# **Annex 1 to Submission by North Somerset Council in respect of Action point 19 ISH 5 -Environmental matters**

## **March 2021**

Following receipt of the cross-sectional details of the proposed Trinity footbridge North Somerset Council as Local Planning Authority considers that in relation to the impacts of overbearing impact and adverse visual impact these may be slightly less severe than we had feared previously

Figure 4: 21st March 4pm

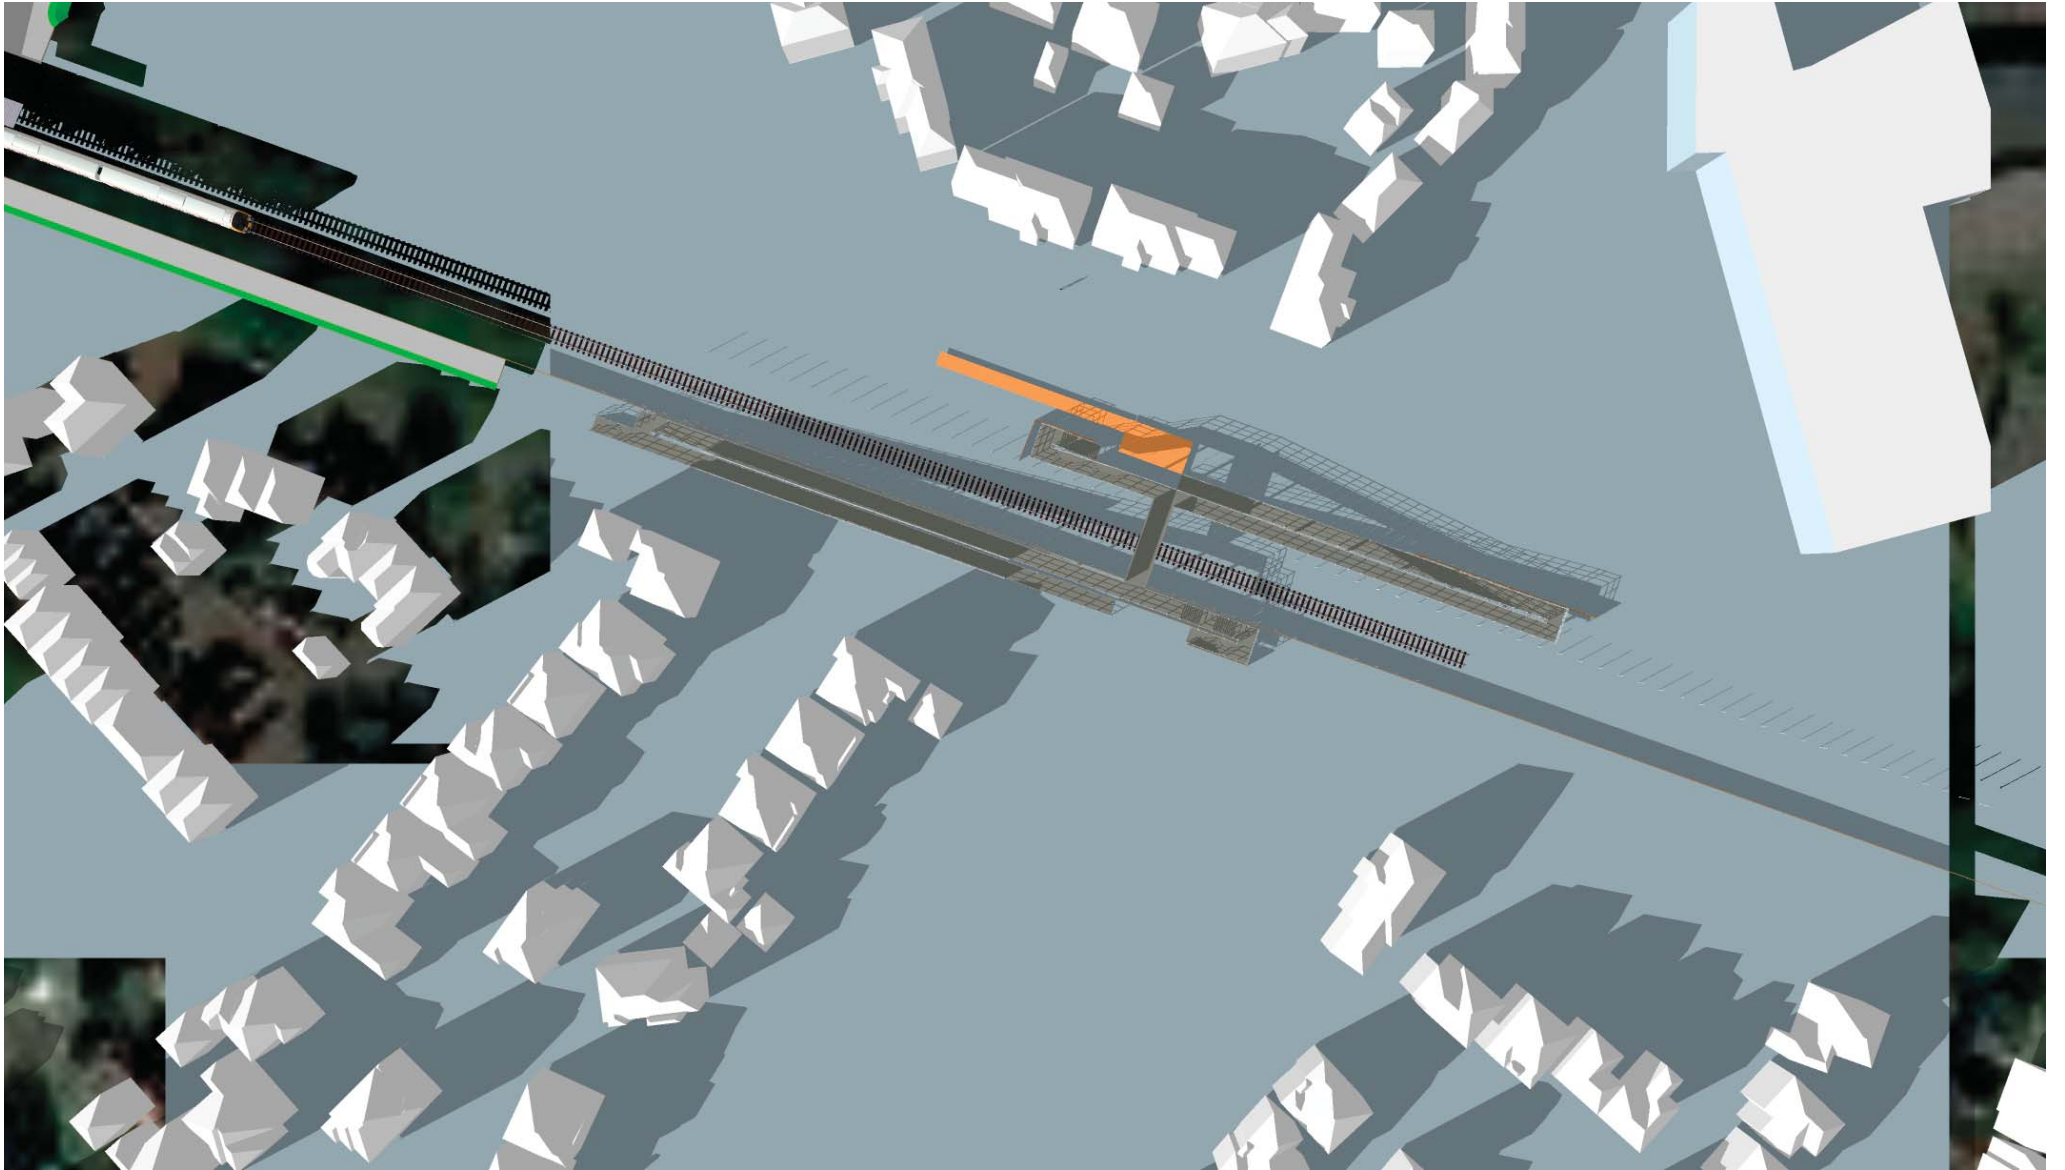
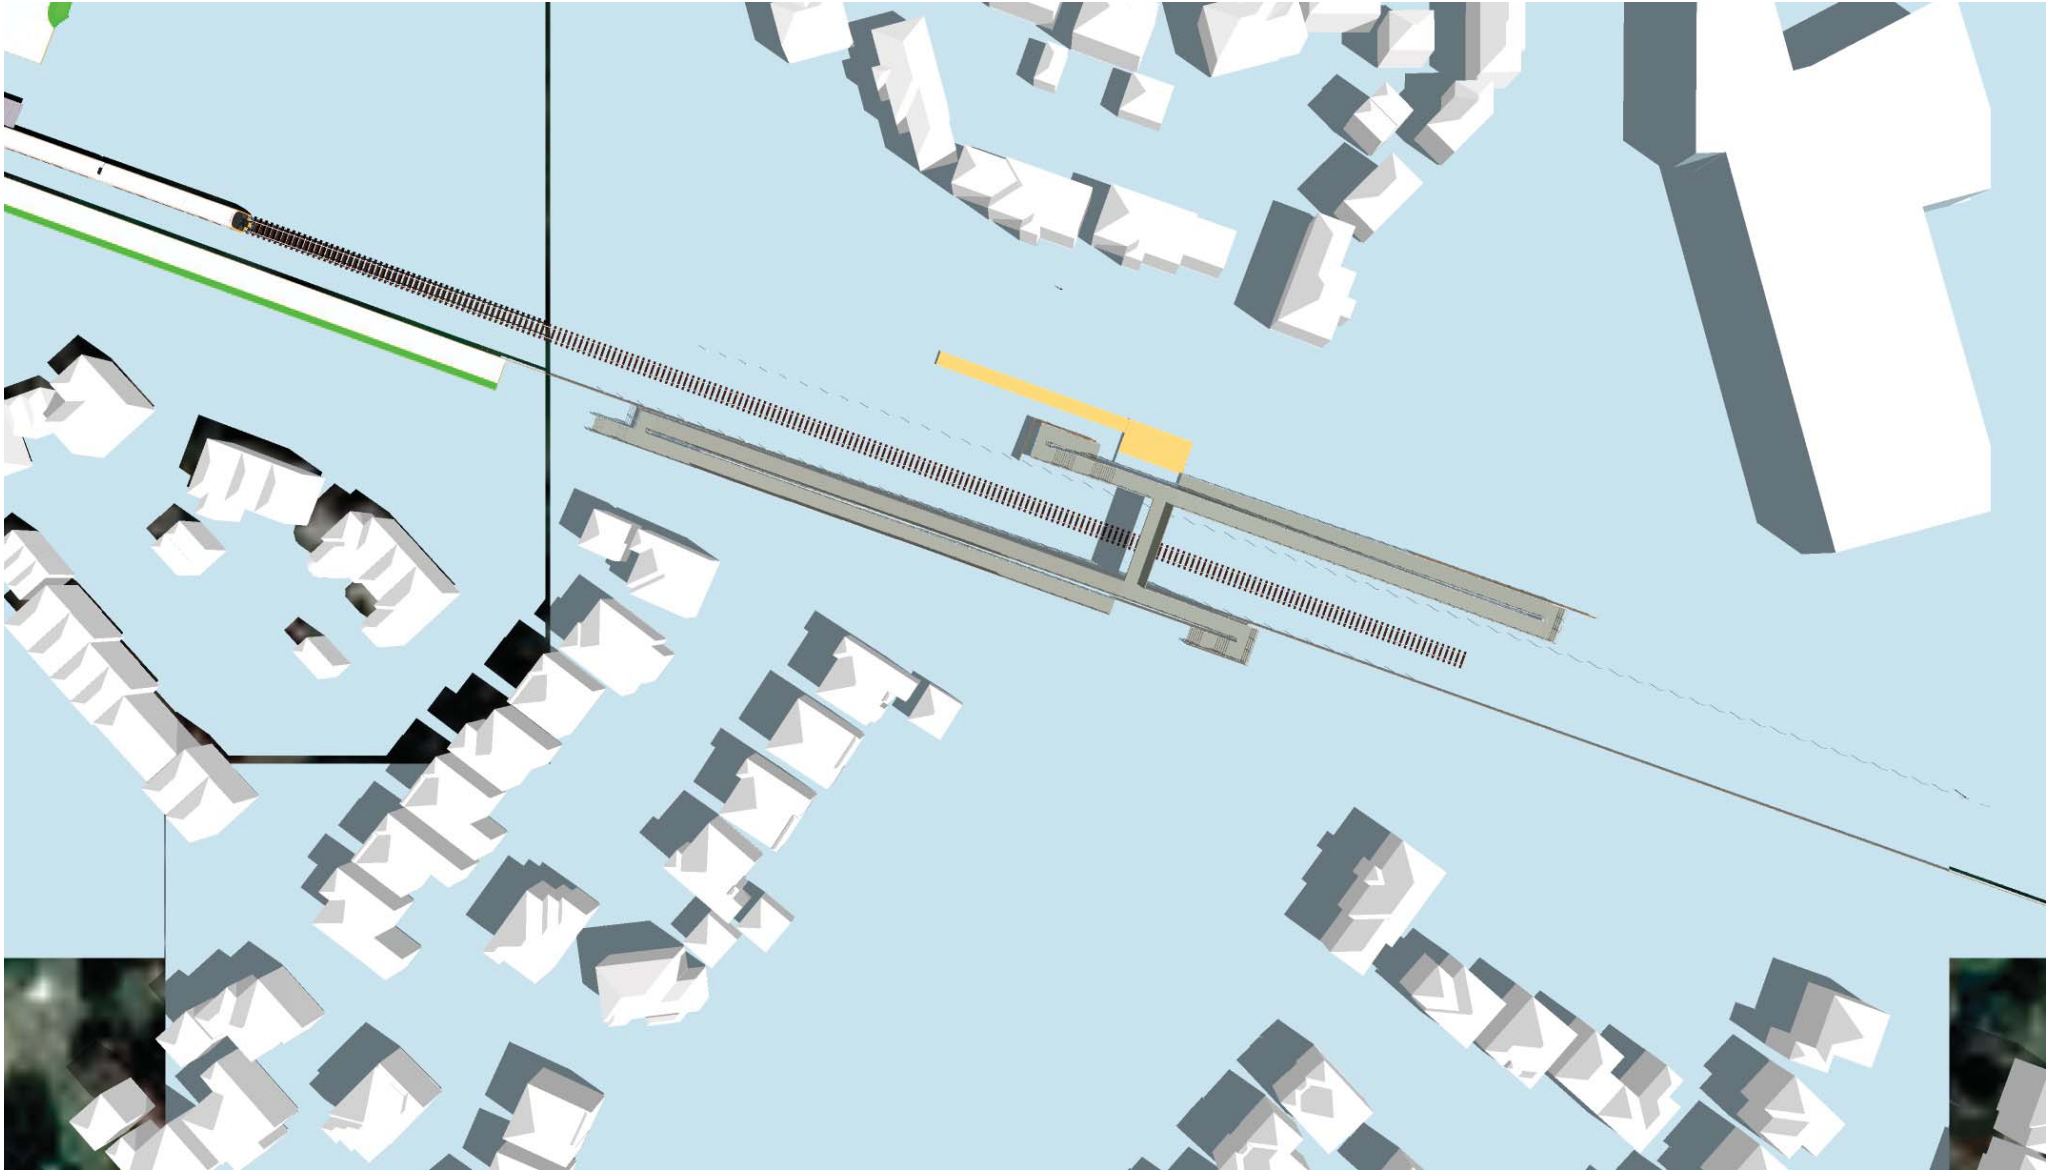
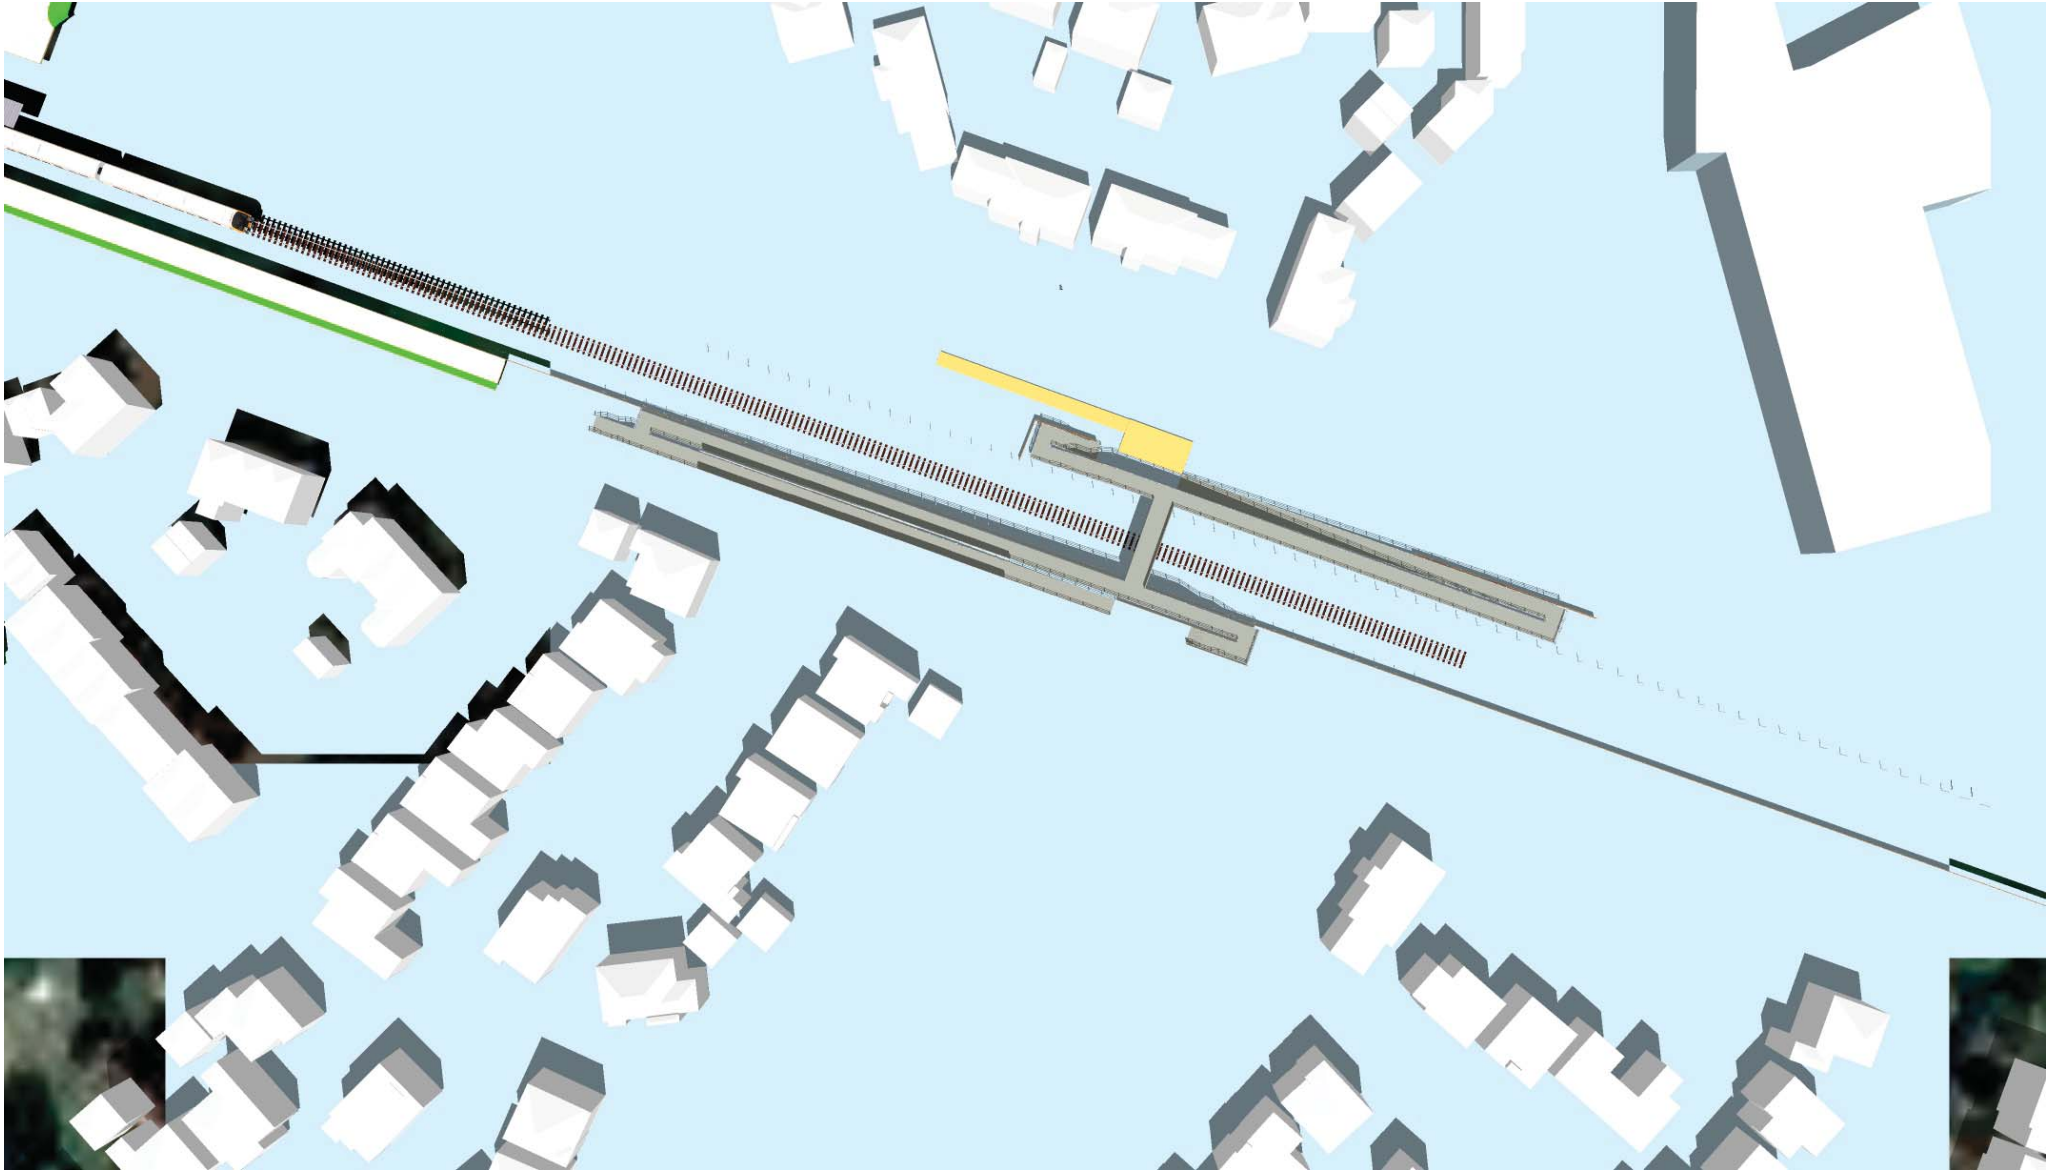
Following receipt of the shadow diagrams it is now easier to assess the impacts that these structures will have on surrounding properties.

The study presents shade impact graphics at 10:00am, 12:00am, 2:00pm and 4:00pm during Spring Equinox, Summer Solstice, Autumn Equinox and Winter Solstice. We consider that this provides sufficient information. From this information, it appears that the footbridge structures have the *potential* to overshadow properties along Tansy Lane (No 9, 11, 15 in particular) rather than properties to the south of the bridge.

From these graphics, it appears that these structures would have no impact at most times and periods of the year on these properties, except for the Winter Solstice
